Recommendation Report for Planning Permission for Works or Extension to a Dwelling

REF NO: F/15/21/HH

LOCATION: 7 Beagle Drive
Ford
BN18 0NY

PROPOSAL: Conversion of garage to habitable use and alterations to fenestration/openings

Mr. & Mrs. MacSweeney
7 The Peregrines, Beagle Drive, Yapton
West Sussex BN18 0NY
PROPOSED ELEVATIONS
Date: August 2021 Scale 1:100 Dwg.no.P.EL. 01

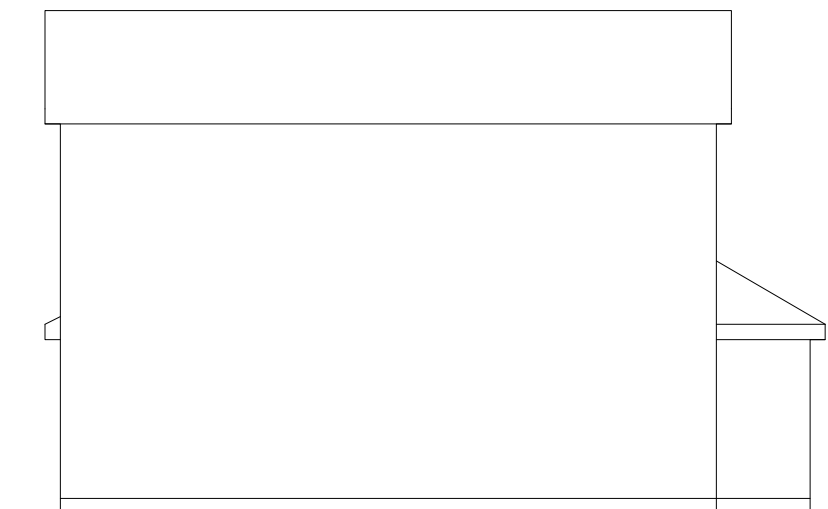
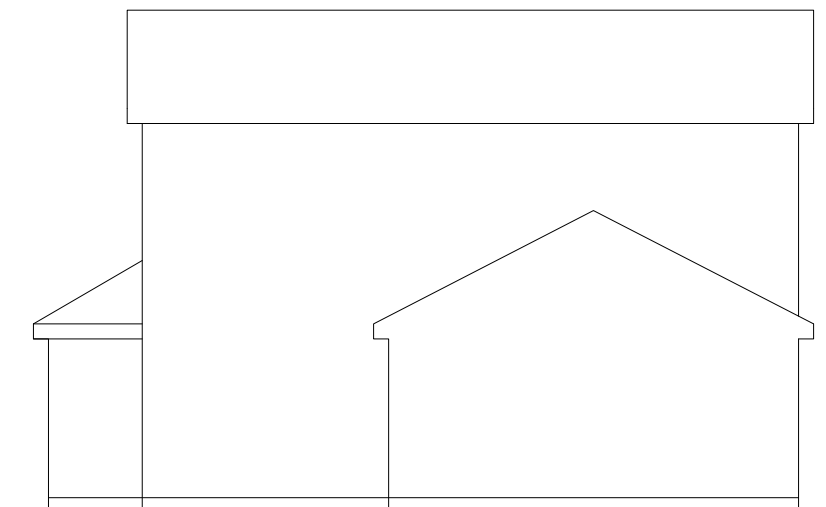
It is proposed to replace the garage door with a UPVC cladding, this type of material is generally considered to be dated and will certainly be out of character for the prominently brick built facades of the buildings along the street. It will be conditioned to provide details of another suitable material to infill the gap left by the garage door and it is recommended that either a facing brick of tile hung facade (like the one to the neighbouring property) would be more appropriate.

- 3 No development above damp proof course (DPC) level shall take place unless and until a schedule of materials and finishes to be used for external walls of the proposed conversion have been submitted to and approved by the Local Planning Authority and the materials so approved shall be used in the construction of the conversion.

Mr. & Mrs. Macsweeney  
7 The Peregrines, Beagle Drive, Yapton  
West Sussex BN18 0NY  
PROPOSED GROUND FLOORPLAN  
Date: August 2021 Scale 1:50 Dwg.no.PR.FP.01

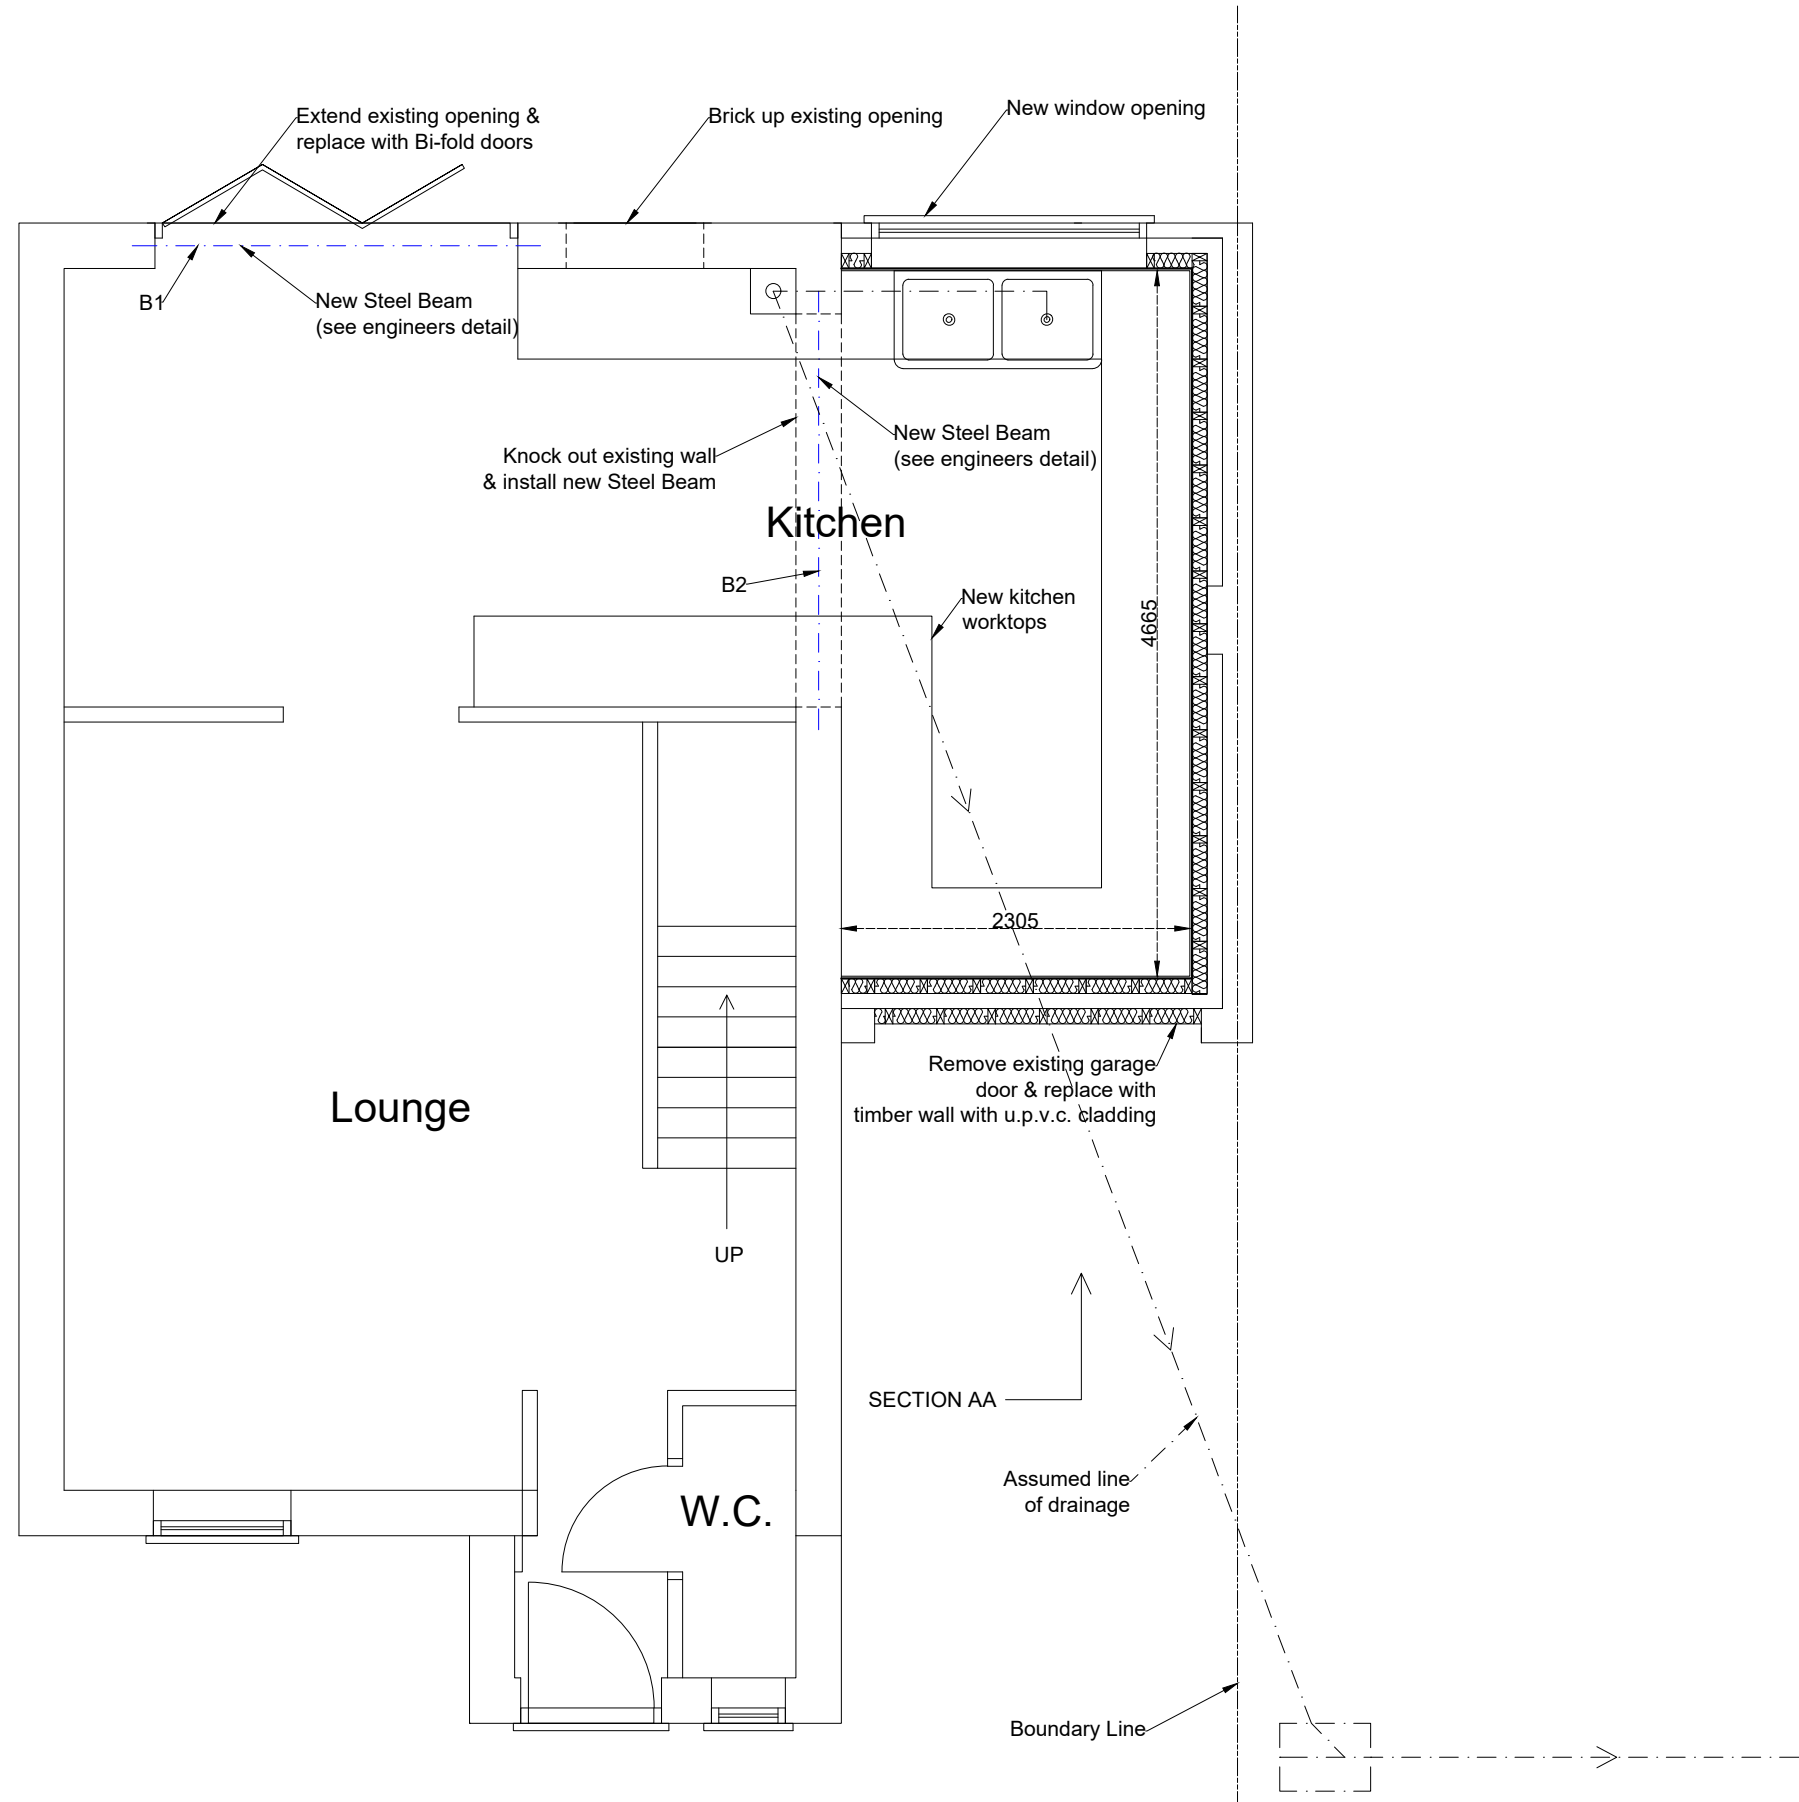
In terms of overlooking, the window to the rear will be at ground floor level and face into the private amenity space of the host dwelling, no views other than those already achievable will be possible from the development.

This proposal results in the loss of 1 parking space on site, the Arun SPG recommends that 3 bed properties have a minimum of 2 spaces per dwelling. The remaining parking to the front of the garage fits 1/2 cars however it is noted that there are no parking restrictions for on street parking of which there is plenty.
